TOWN AND COUNTRY PLANNING ACT 1990 FULL

Reference:	H23-1158-20	Date of Decision:	17th February 2021
Applicant:	Mr D Carroll Springway Stockwell Gate Whaplode Spalding PE12 6UE		
Location:	Springway Stockwell Gate Whaplode Spalding		
Description:	Demolition of dwelling and erection of 3 houses

South Holland District Council hereby give notice that this application has been REFUSED for the above proposal for the following reason(s):

Drg No 3090 - 302 rev C

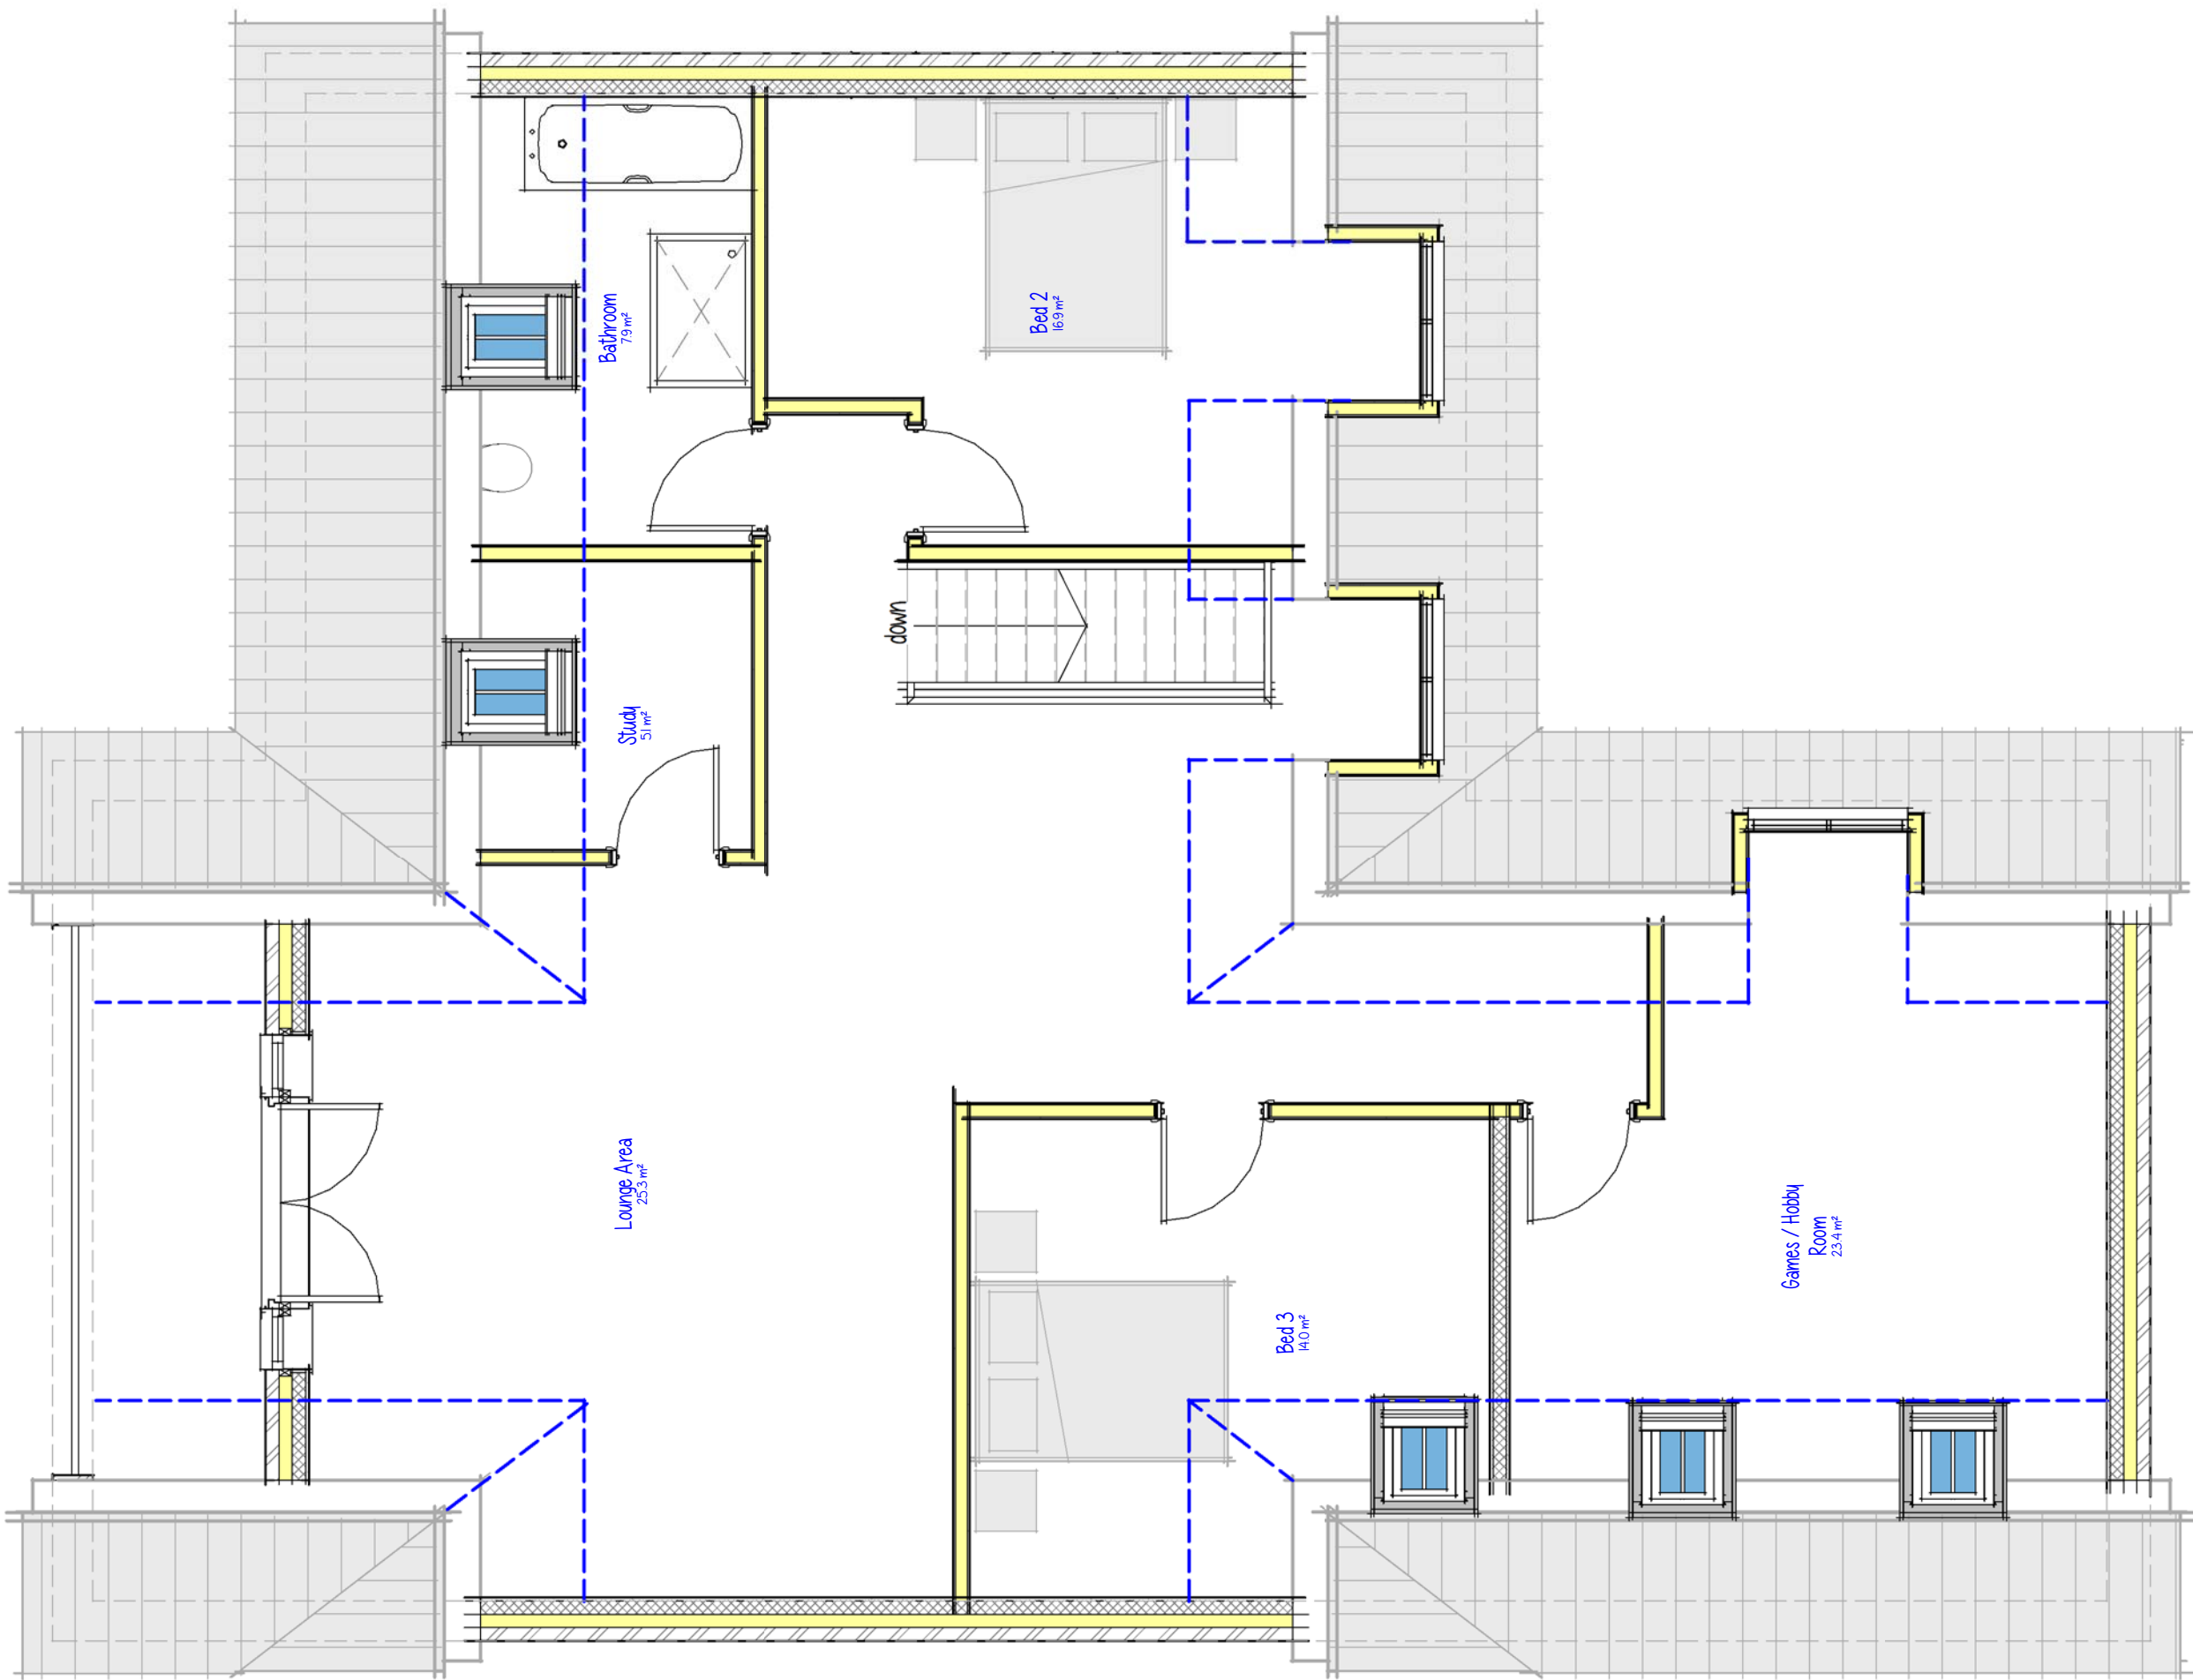
The separation distance between the dormer window of Plot 3 facing eastwards and the rear of Plot 1 would not be sufficient to prevent significant overlooking between primary windows and from a primary window to private domestic garden. Moreover, Plot 3 would not have a well-defined and sufficiently sized garden to appropriately ensure an external amenity area for the enjoyment of future occupiers.

Moray
3090 - S02 rev C

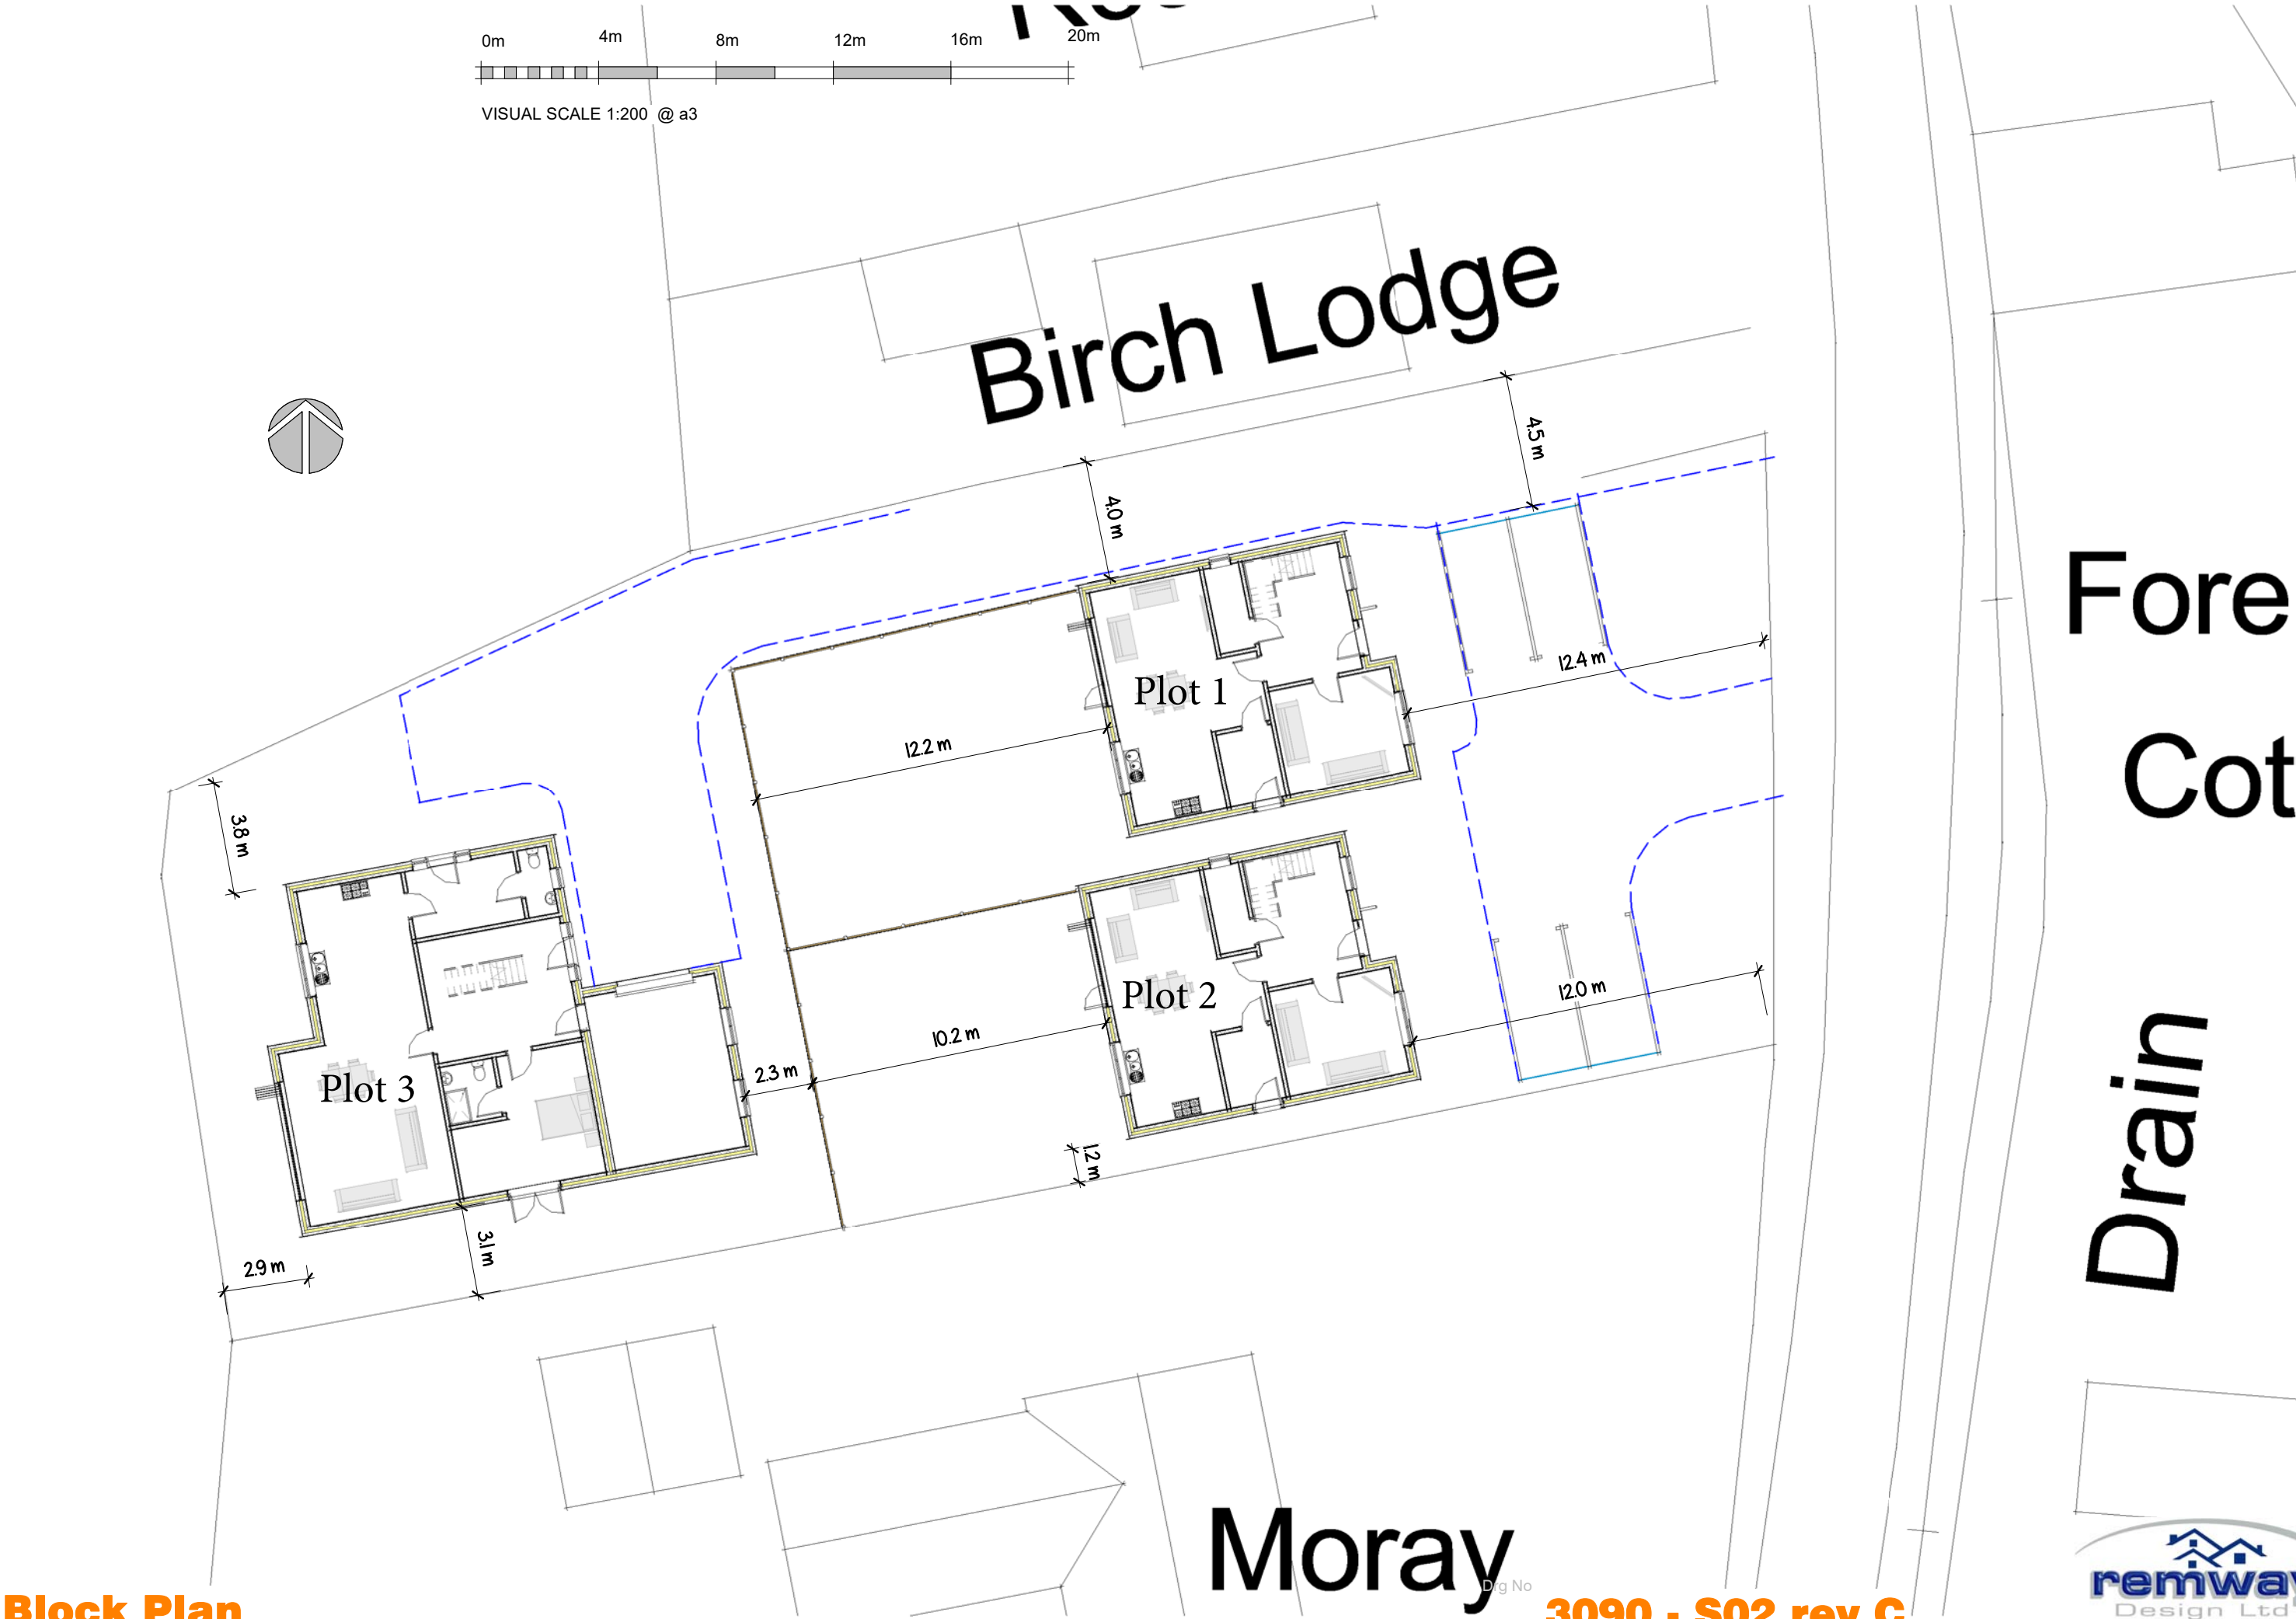
The built environment in the surroundings of the site consists of a well-defined ribbon development onto Stockwell Gate. The erection of Plot 3 to the rear of the other two plots would unduly harm the linear pattern of development which defines the character of the local area. The Local Planning Authority is mindful of several domestic curtilages nearby having outbuildings to the rear of the dwellings. However, none of them are an independent building for permanent residential use but for incidental enjoyment of the dwellings.

The proposed plots onto Stockwell Gate would have 4 bedrooms and no in-built garage. Two parking spaces on the driveway are only provided per plot and there should be one further to prevent on-street parking.
